**KIRKLEES METROPOLITAN COUNCIL
INVESTMENT & REGENERATION SERVICE**

DELEGATED DECISION TO DETERMINE PLANNING APPLICATIONS

Reference No:	2025/62/90970/W
Site Address:	384, Wakefield Road, Dalton, Huddersfield, HD5 8DY
Description:	Erection of two storey side extension with balcony to rear elevation and associated alterations
Recommending Officer:	Elenya Jackson

OFFICER REPORT

Proposed Left Elevation
1 : 50

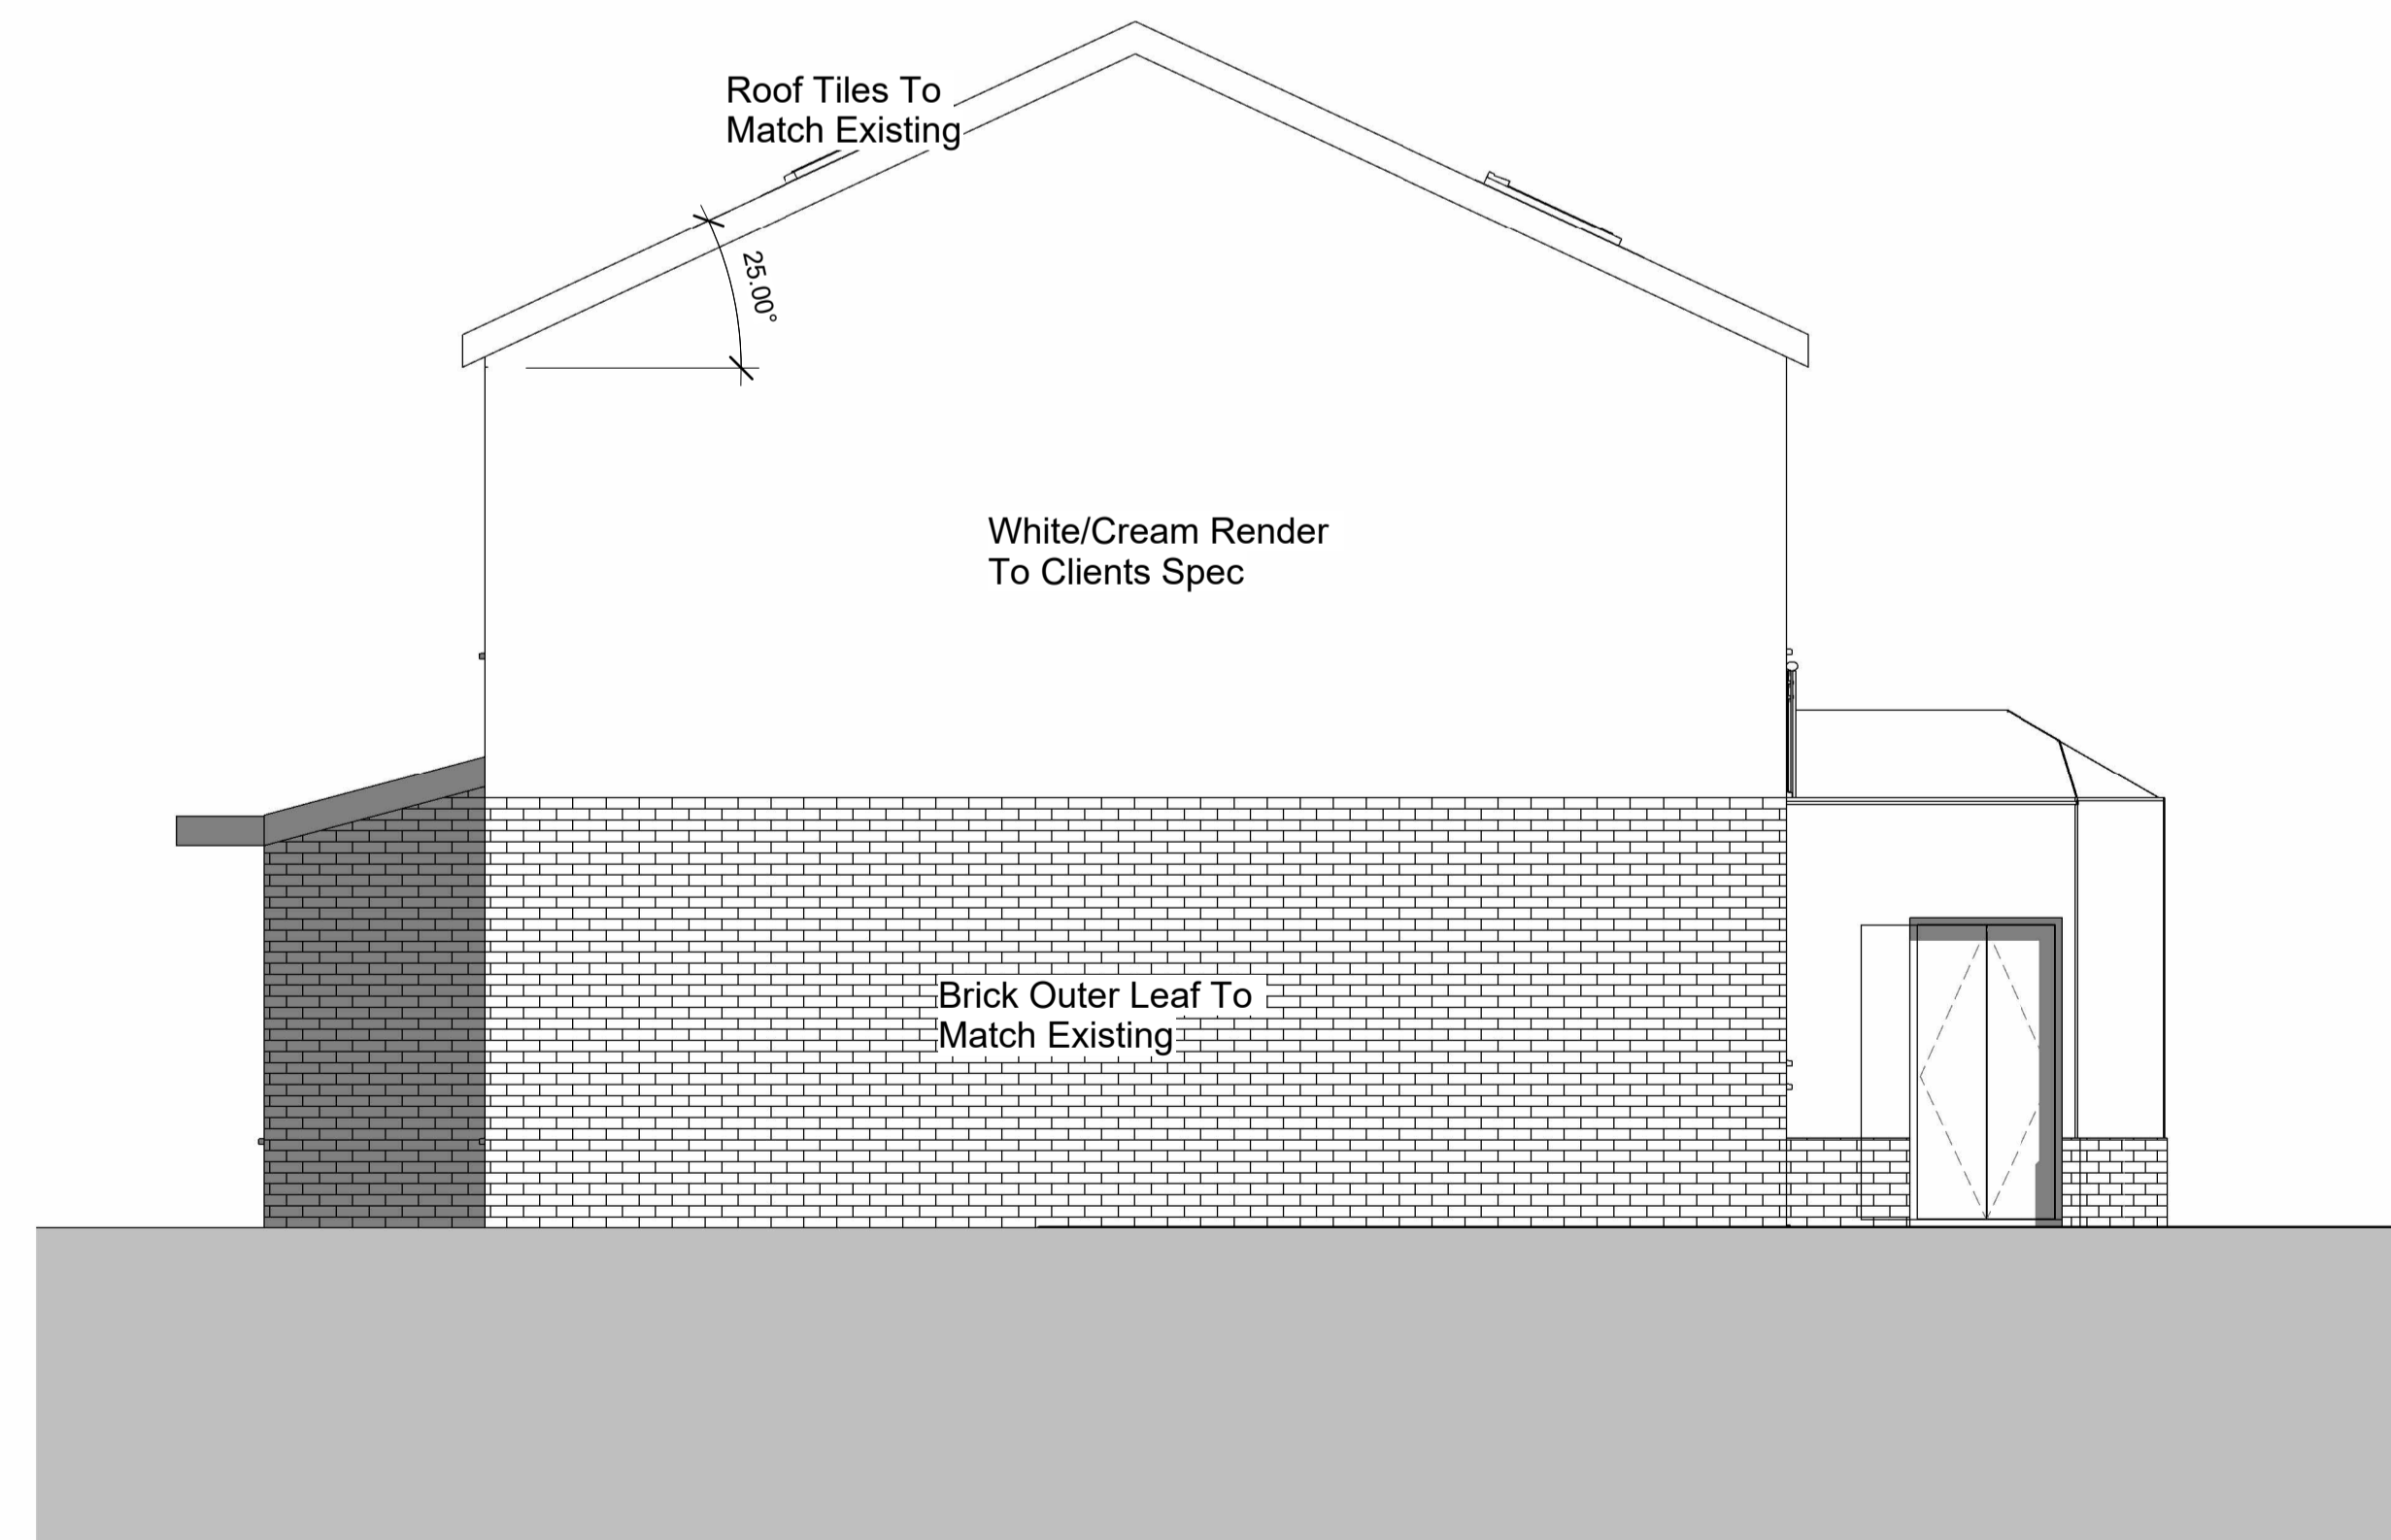
Officers note that the proposal would be flush with the front elevation of the existing dwelling; however, there is not a uniform design within the street scene and due to the spacing with adjoining neighbours, the property largely appears as a stand alone building.

The proposal would retain a gap of more than 1m from the shared boundary as required by the SPD, and therefore would not significantly impact spacing in the street scene.

The proposal would result in alterations to the external appearance of the dwelling as a whole, by introducing render. Officers consider that as there are examples of render in the vicinity and as the properties that form the street scene are not uniform, the alterations to the dwelling would be acceptable in this instance.

Overlooking: The proposal would feature rear facing windows; however, these would not extend closer to no.3 than the host dwelling and would therefore continue the existing relationship between the properties.

Project Name 384 Wakefield Rd, Huddersfield, HD5 8DY	
Drawing Title: Location & Proposed Site Plan	
Drawing Number: TR-A25-0103-A4	Scale: As indicated@A1
Date: 04/07/25	Revision: A
Drawn By: AM	Checked by: JA
Reason For Issue: Planning

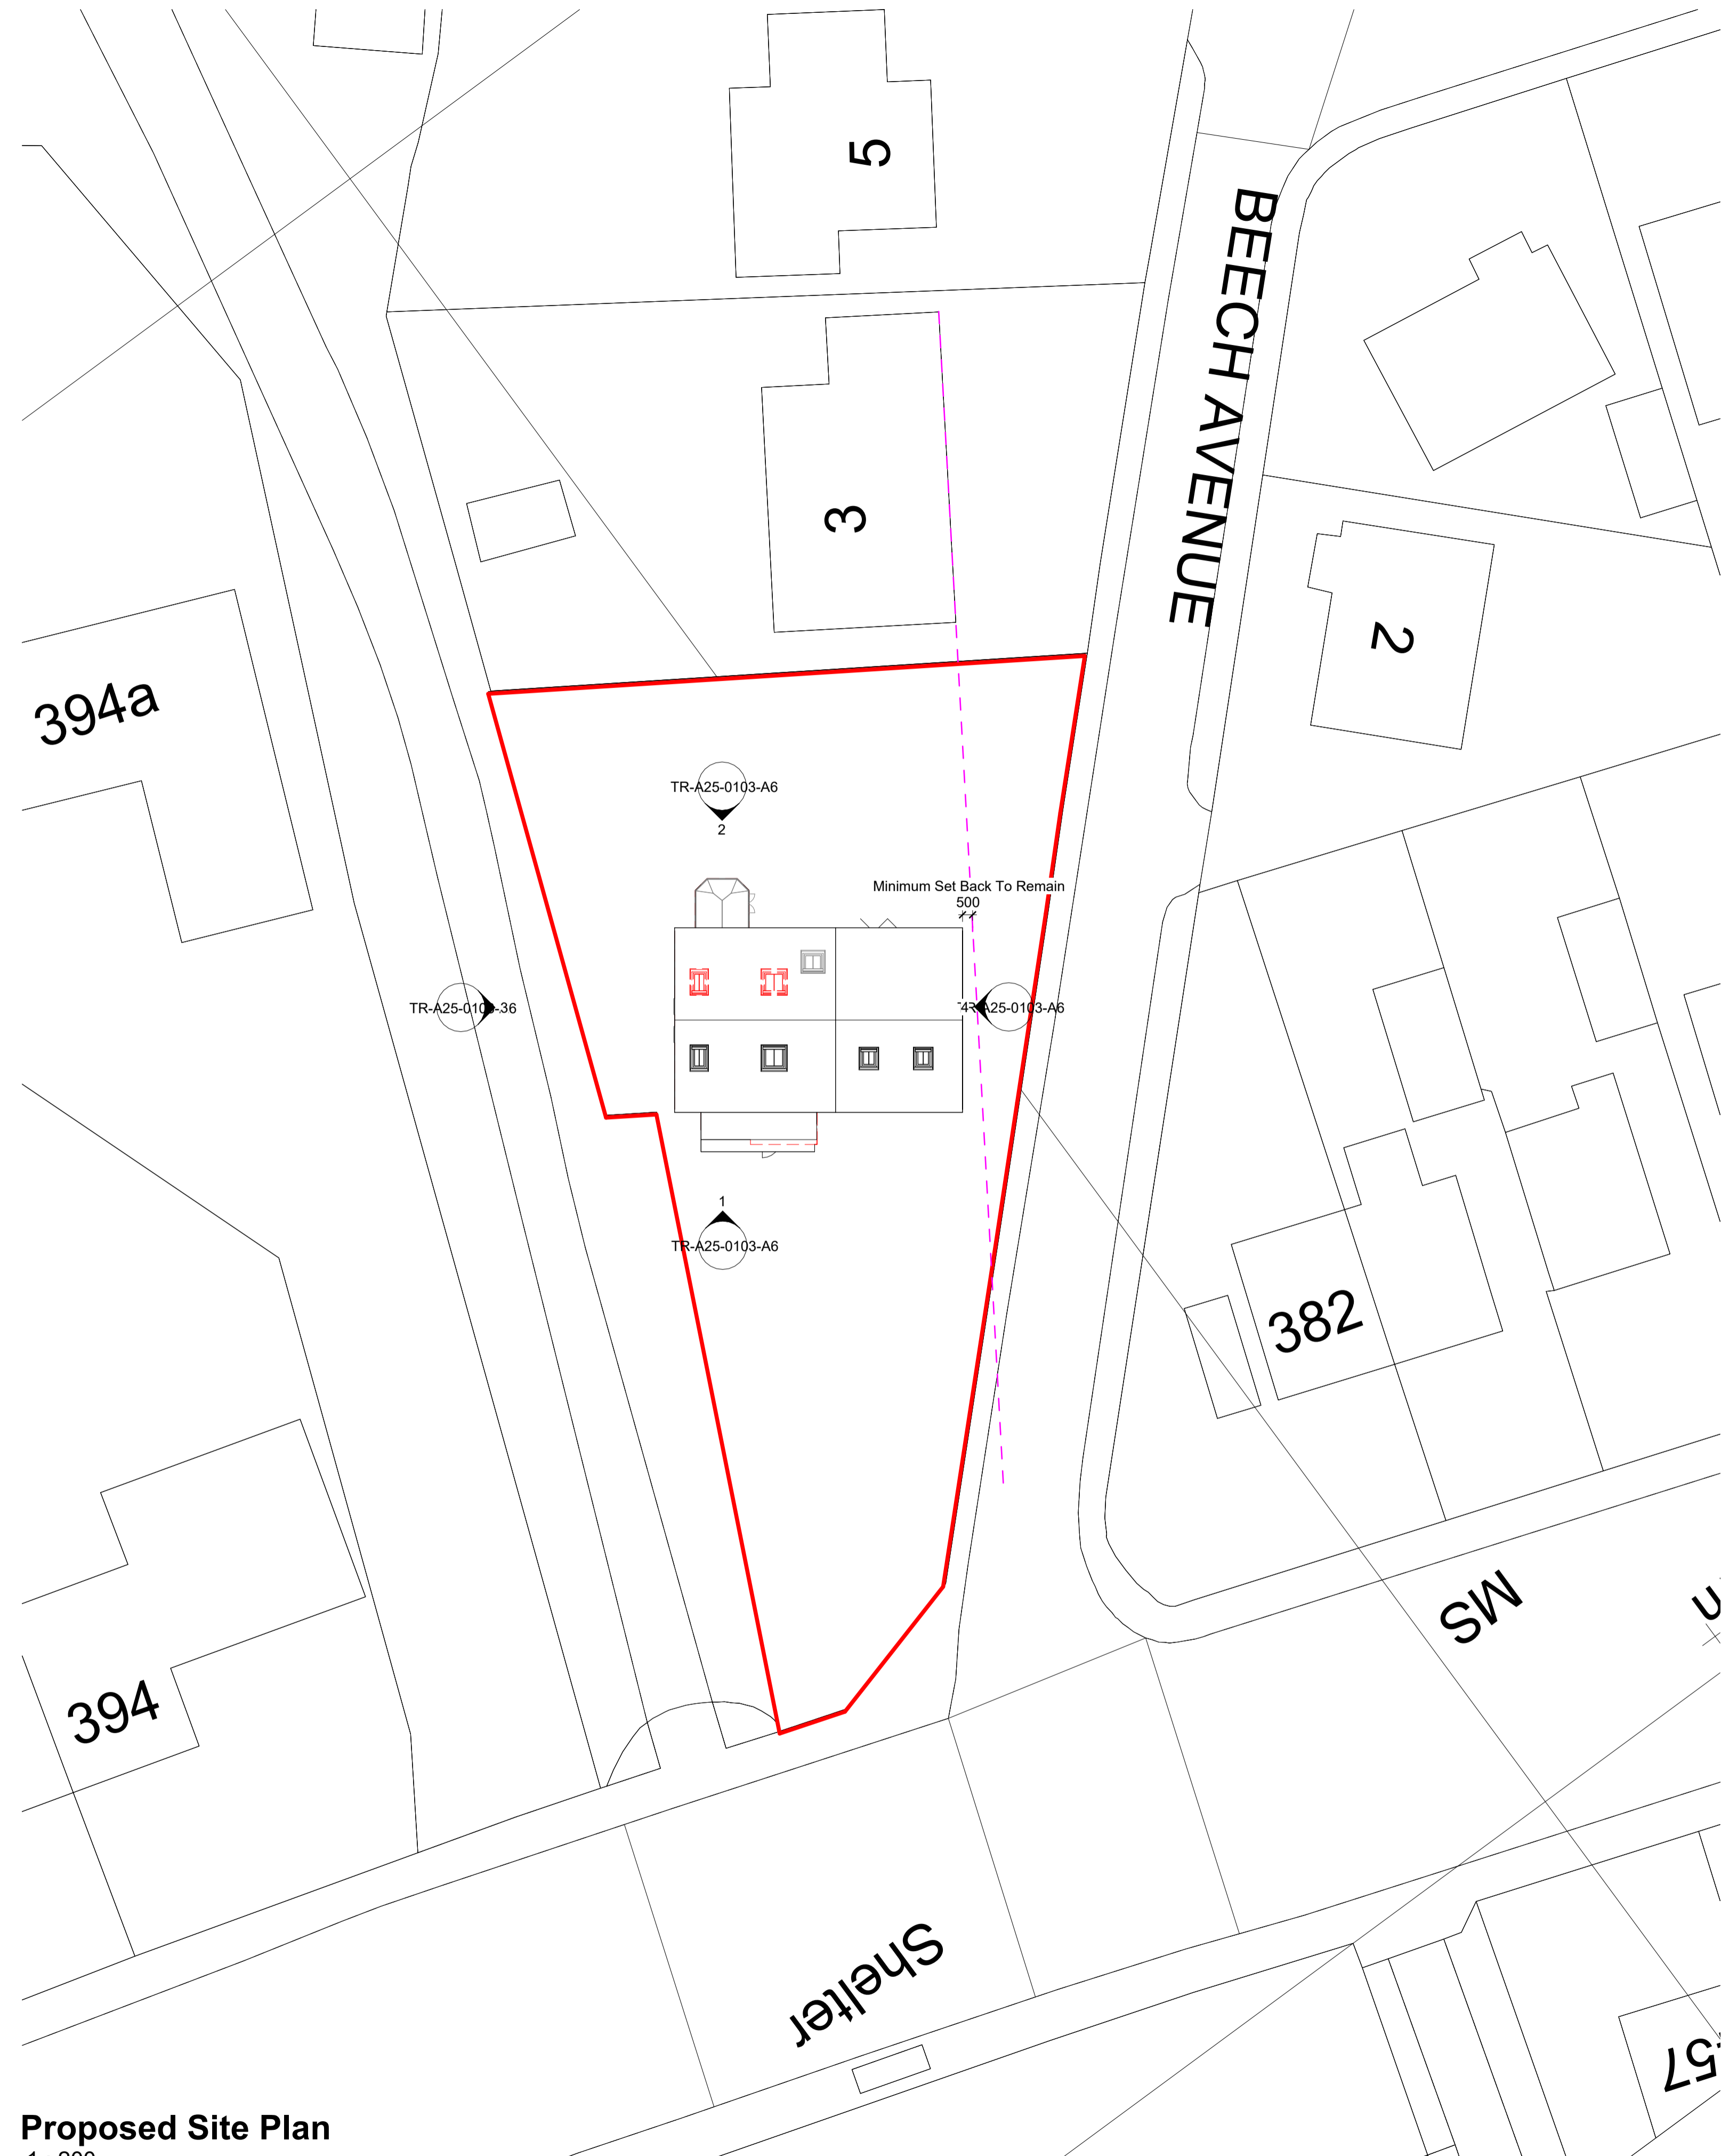
Officers requested a reduction to the width of the proposal due to it extending beyond the building line of the adjoining street (Beech Avenue). The applicant provided supporting evidence that the proposal would not extend beyond the front elevation of no.3 Beech Avenue and updated site plans were provided to demonstrate this.
